505 Fore St - permit SIGN2018-00047

I have completed my initial zoning review of the sign permit. I need some more information before I can approve it.

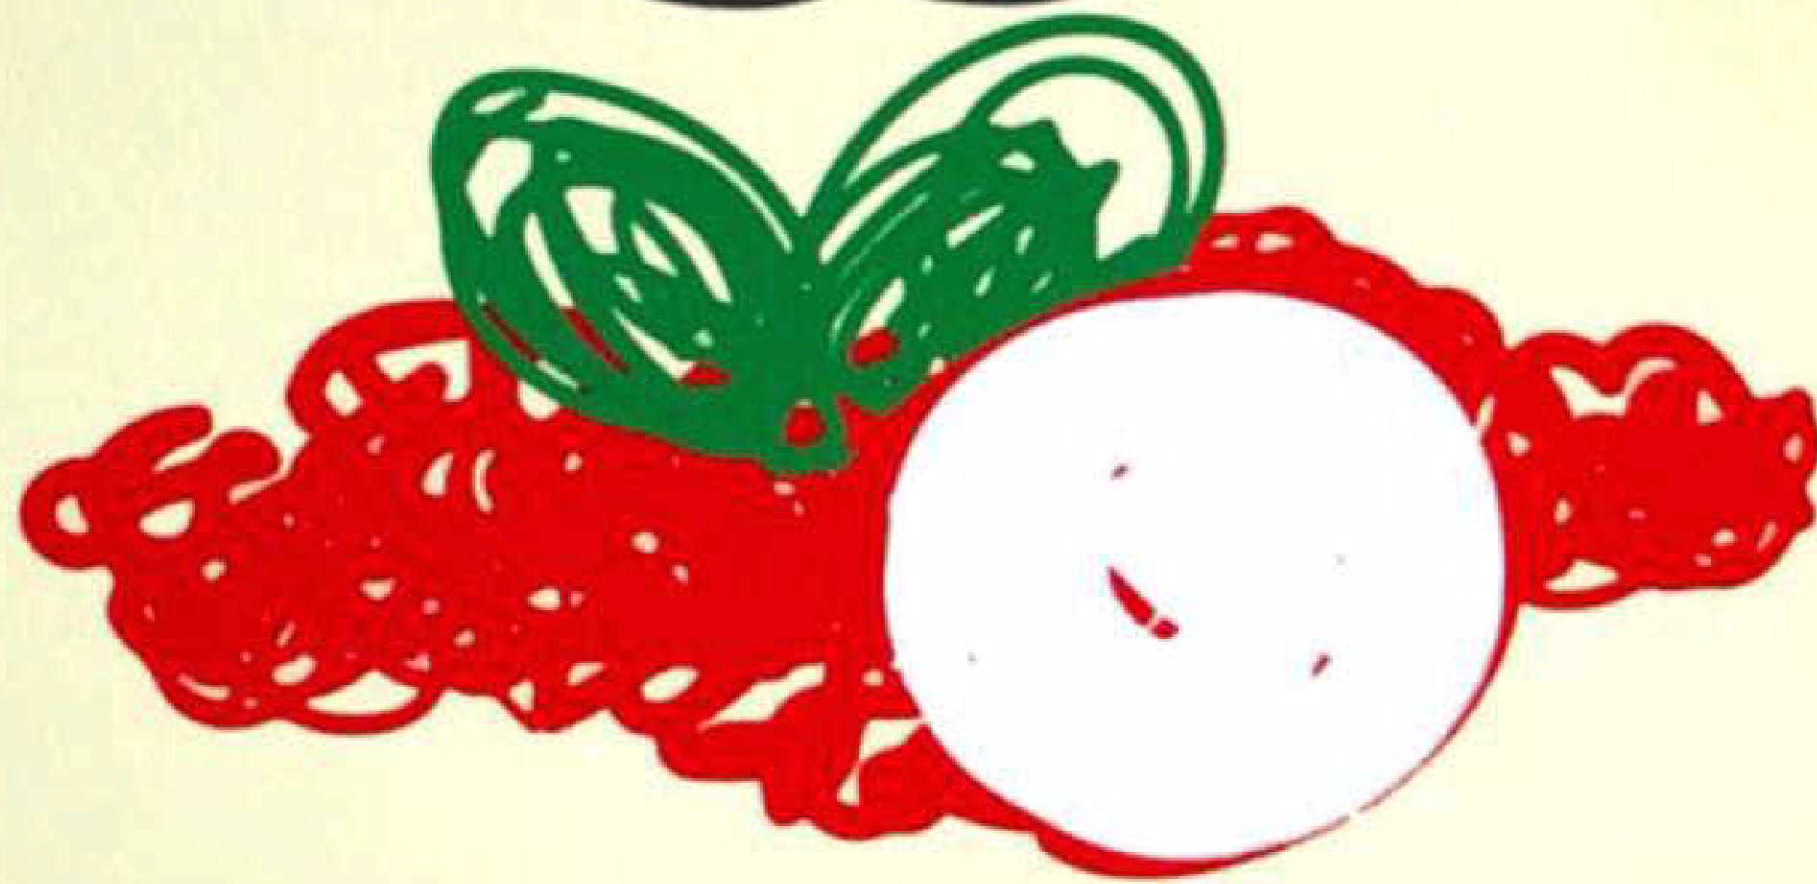
1. I need to know what material the sign is made out of.
2. I need to know how the sign will be attached to the bracket.

Good afternoon Ann,
The material is vinyl mounted on
dibond frame and will be hang to the wall bracket with the existing hook. I f You need some more specifics I can hear
directly from M&H sign
Hope this explanation gonna be ok
Please let me know
Have a great weekend
Stefano Zurleni

1. The sign is made of printed adhesive vinyl mounted on 1/8" thick Aluminum Composite Material (ACM).
2. The sign will be screwed to the bracket face.
